17 May 2021

File No: 2021/203545
Our Ref: R/2019/6/C
Your Ref: SSD-10340-Mod-1

Fort Street Public School Redevelopment - SSD 10340 Mod 1 - Design and layout changes

Materials Sample Board

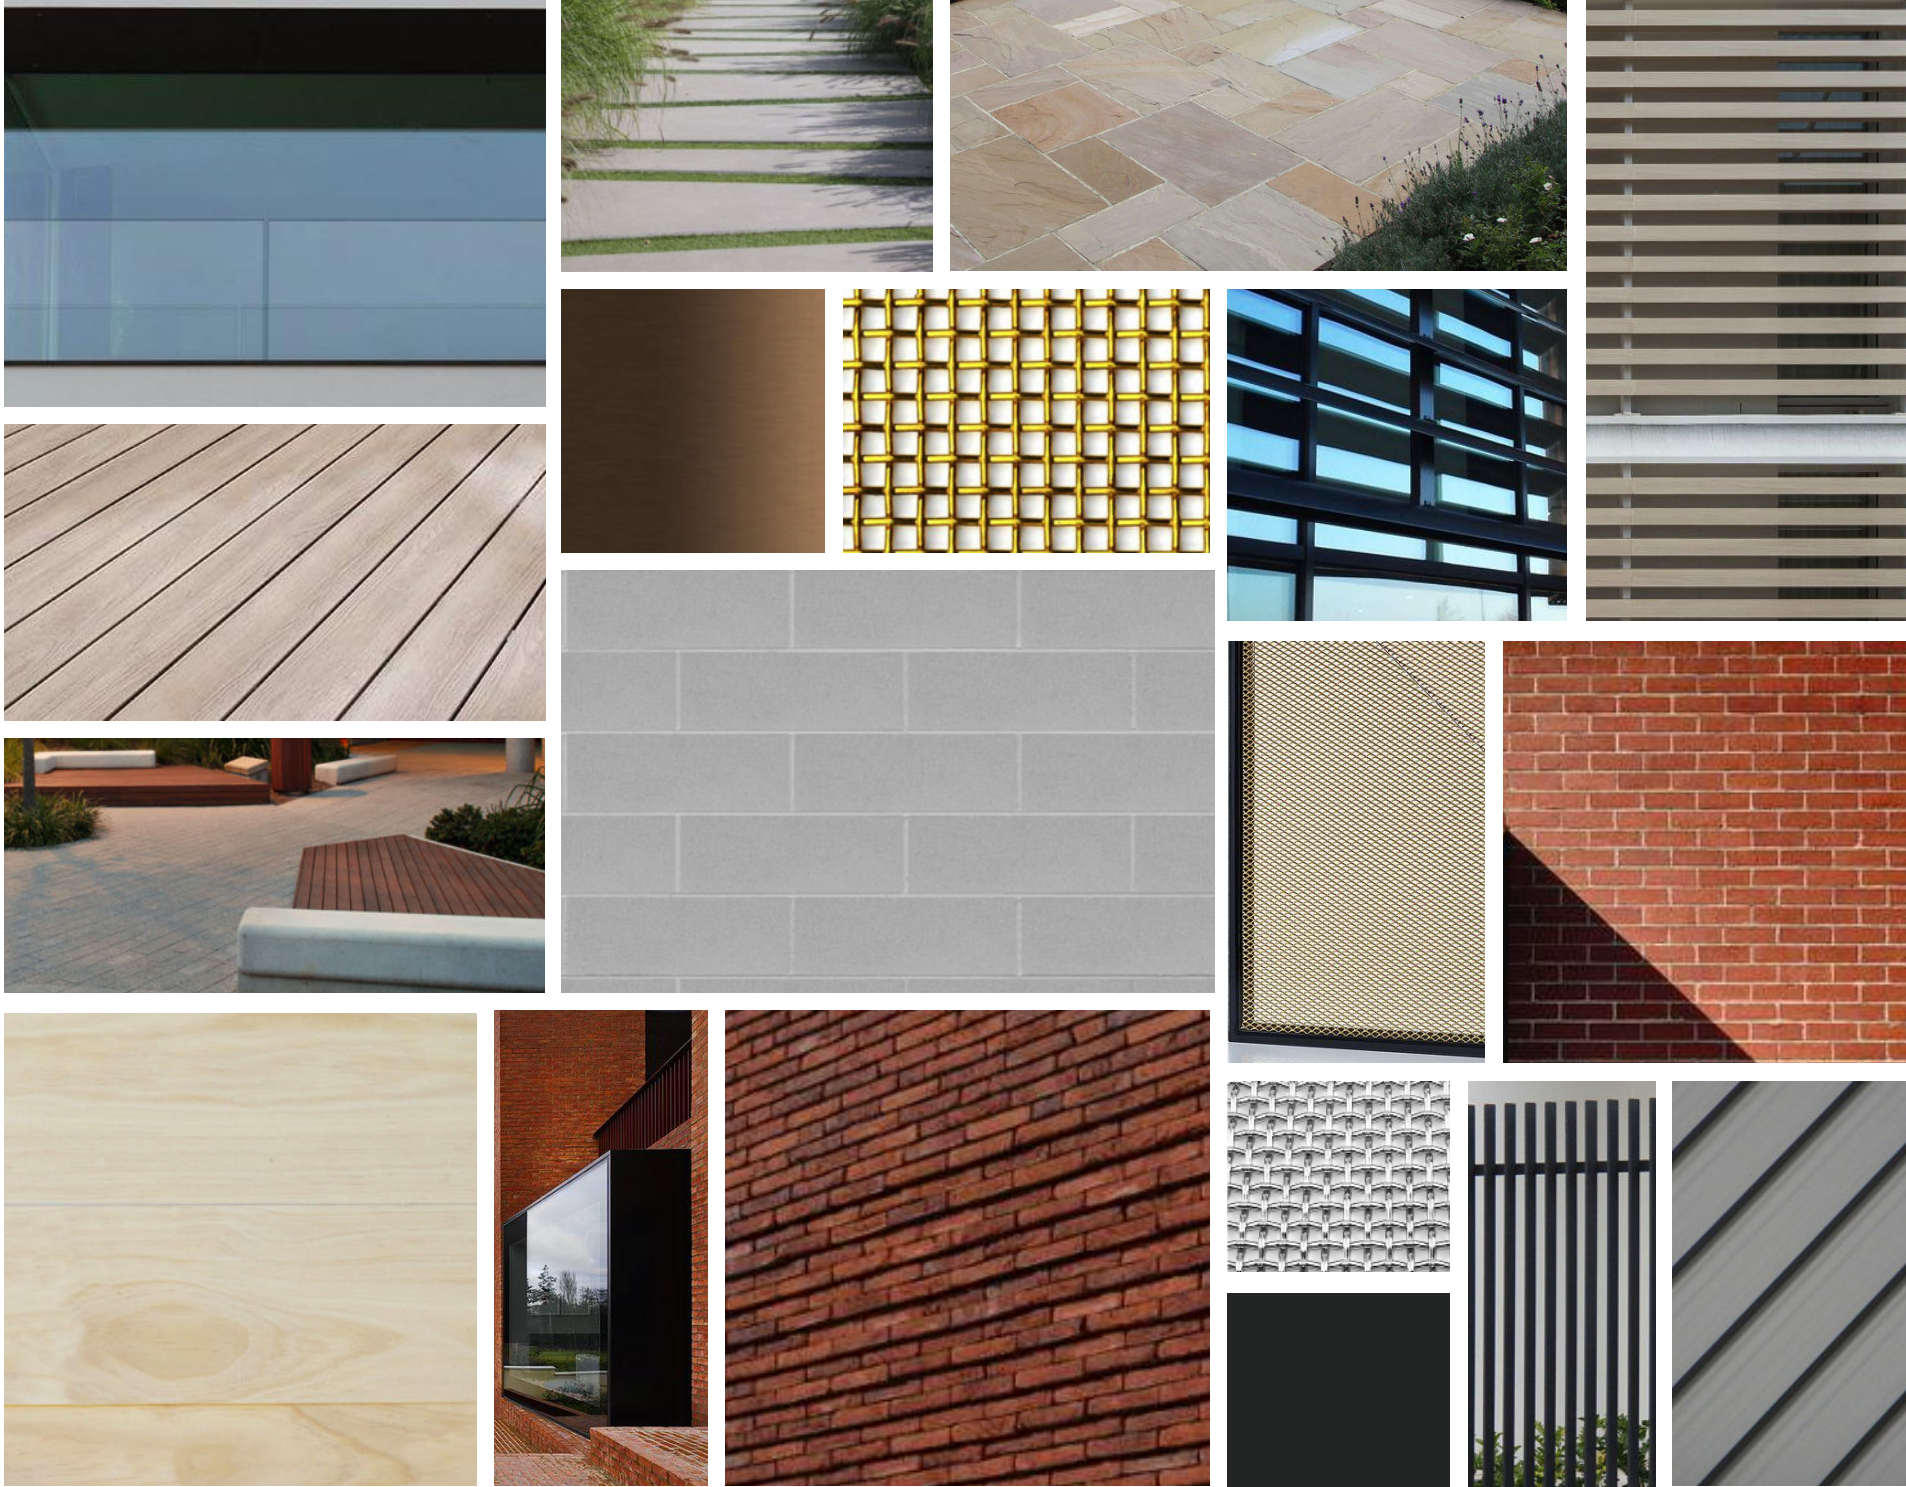
Regarding the extensive use of glazing proposed, the materials and finishes schedule should specify clear glass with a shading coefficient of less than 30% to ensure the glass is clear and colour-neutral. Based on the products presently specified, it is likely the glass will need to be Solarban 60(2) Solarblue + Clear.

/ C.O.L.As and Colonnades - Revised Structure and Materiality

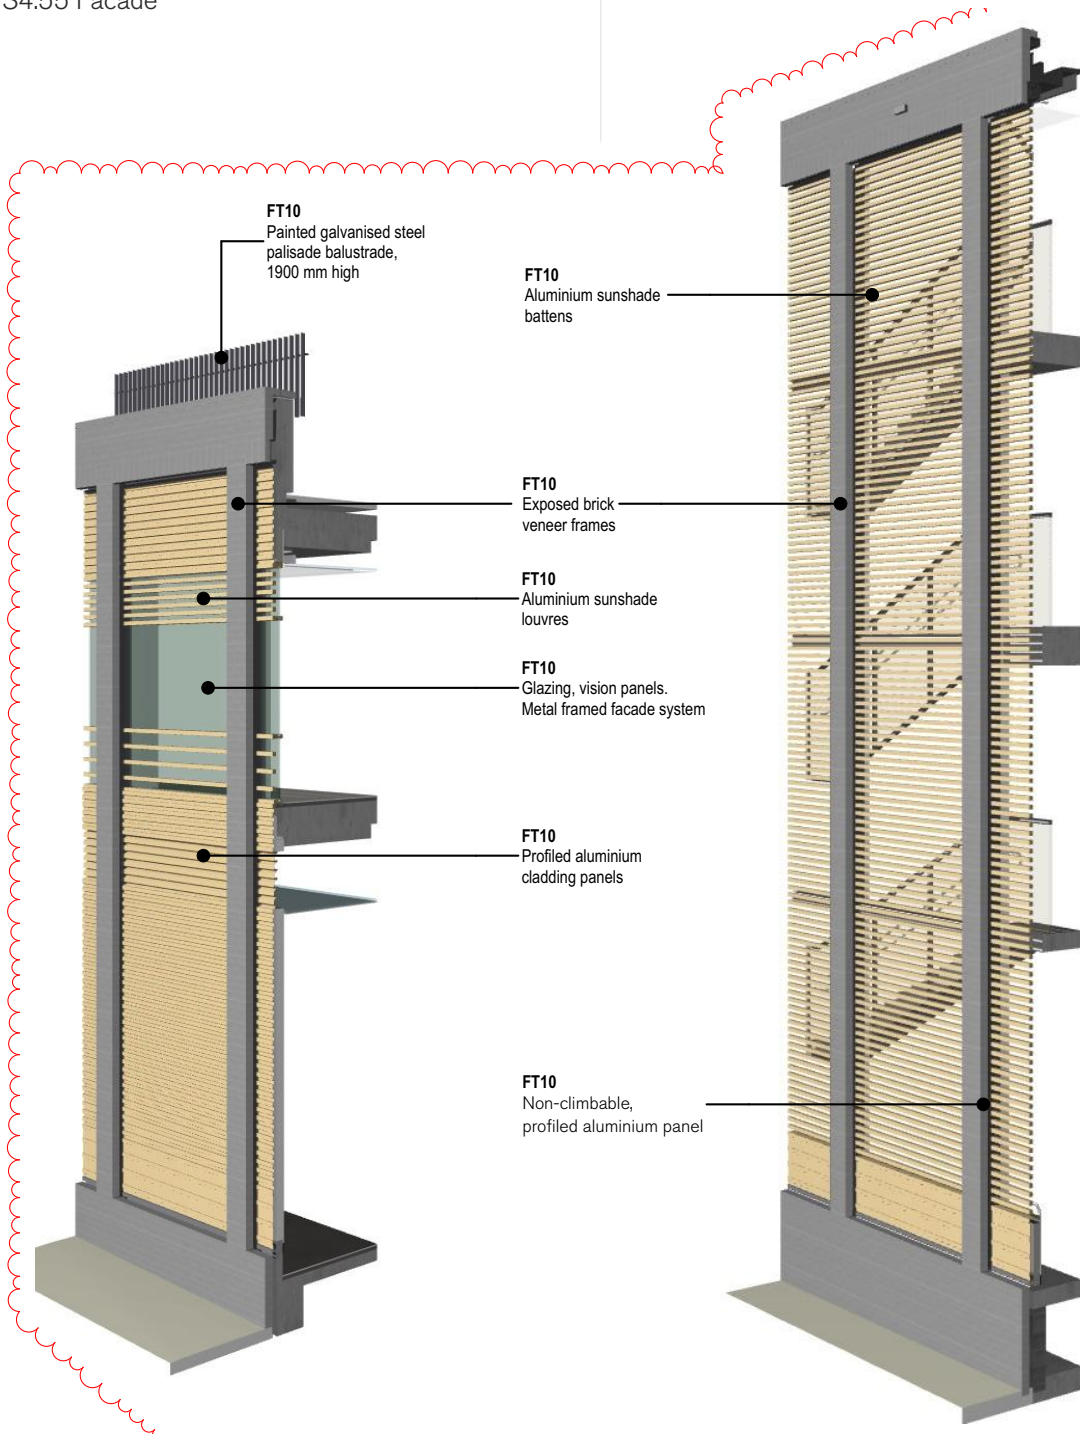
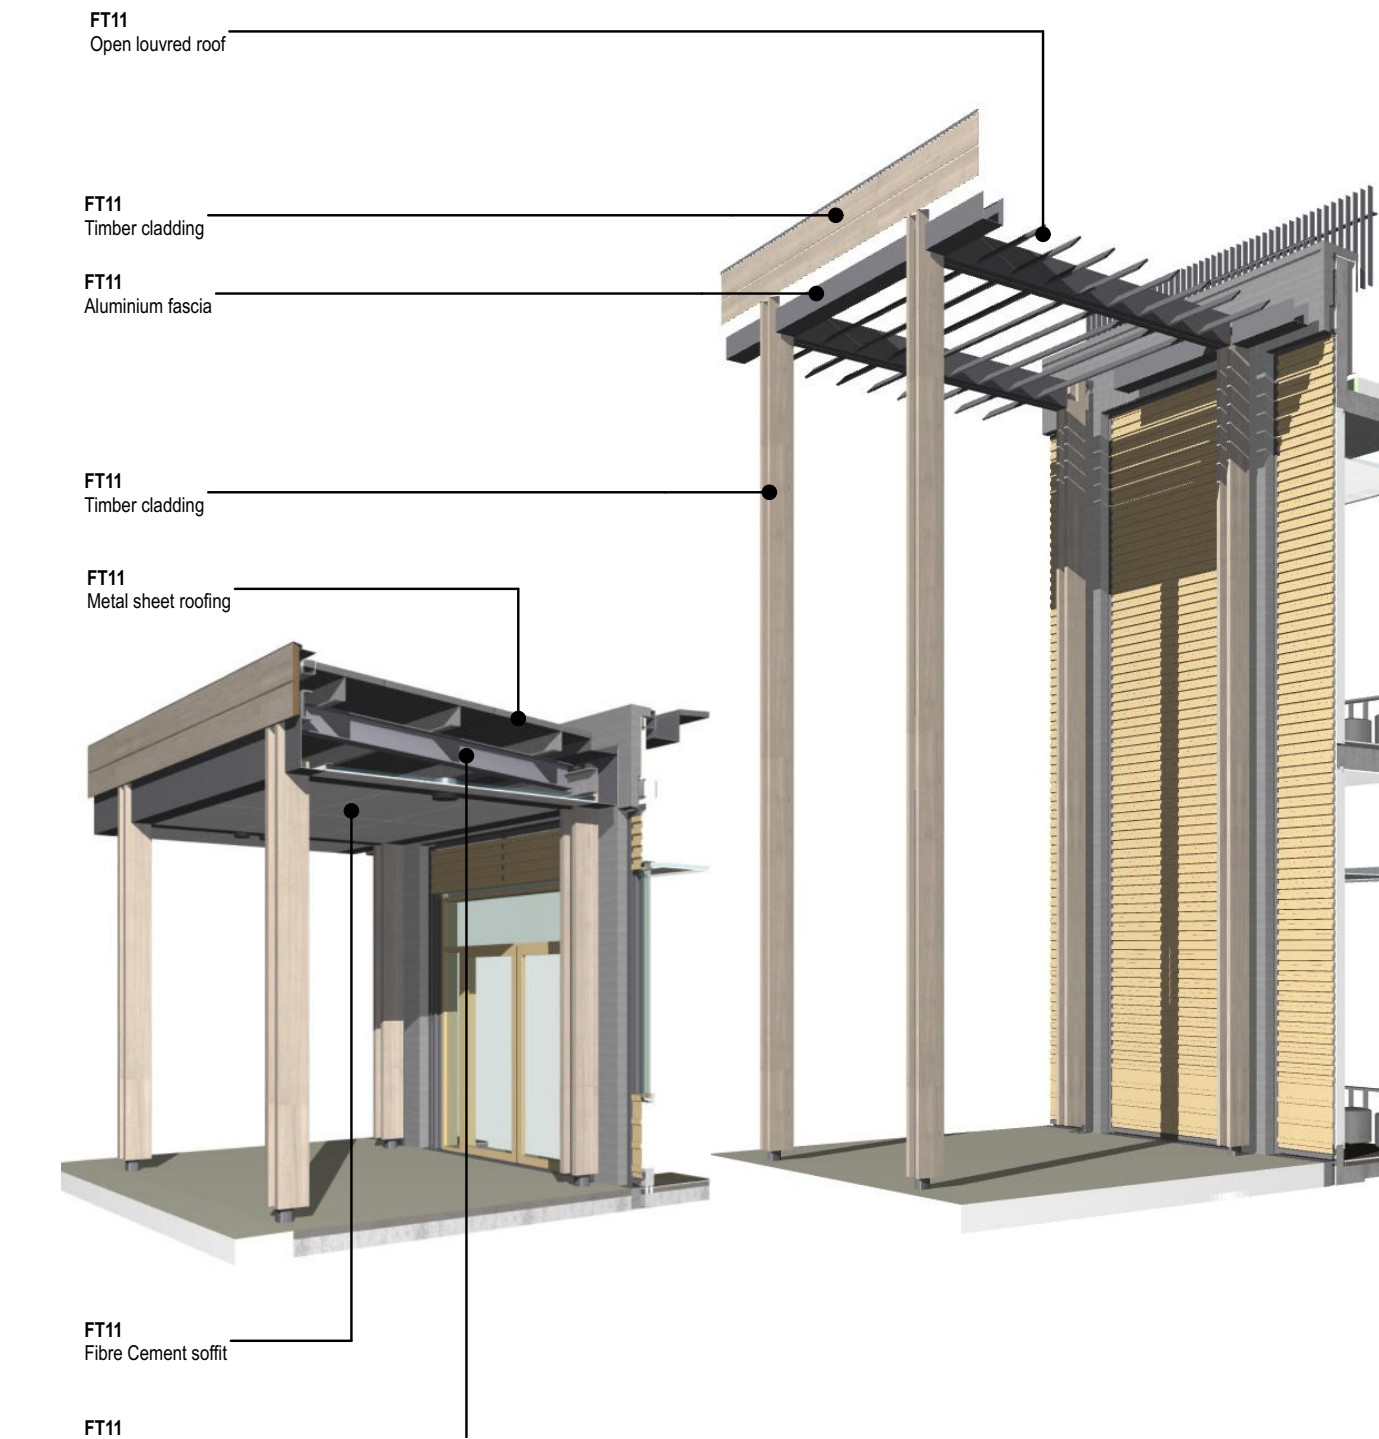
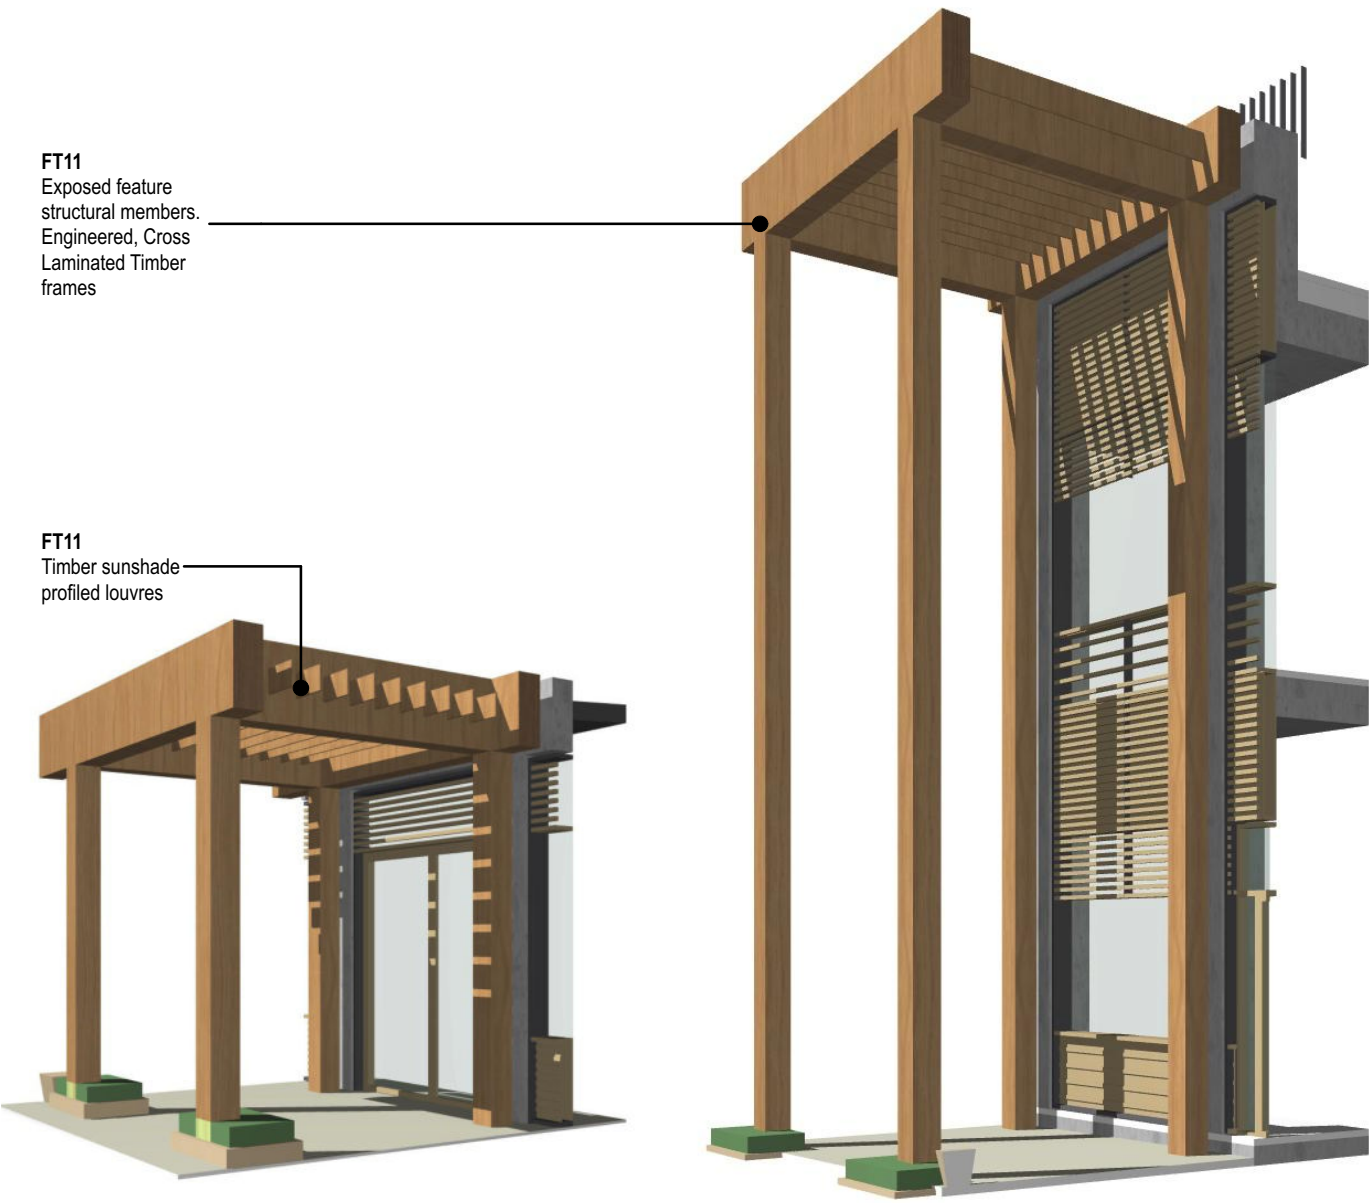
The modification application has deleted the proposed trellises that contained vines for greening and shading throughout the site, and eight trees have been removed for their installation. These elements have been replaced with metal awnings. While these covered outdoor learning areas (COLAs) do provide some shade, their metal roofs emit heat into the surrounding environment, unlike trees and vines that actively cool the air. This will result in a poor school cooling outcome. The removal of these elements is not supported.
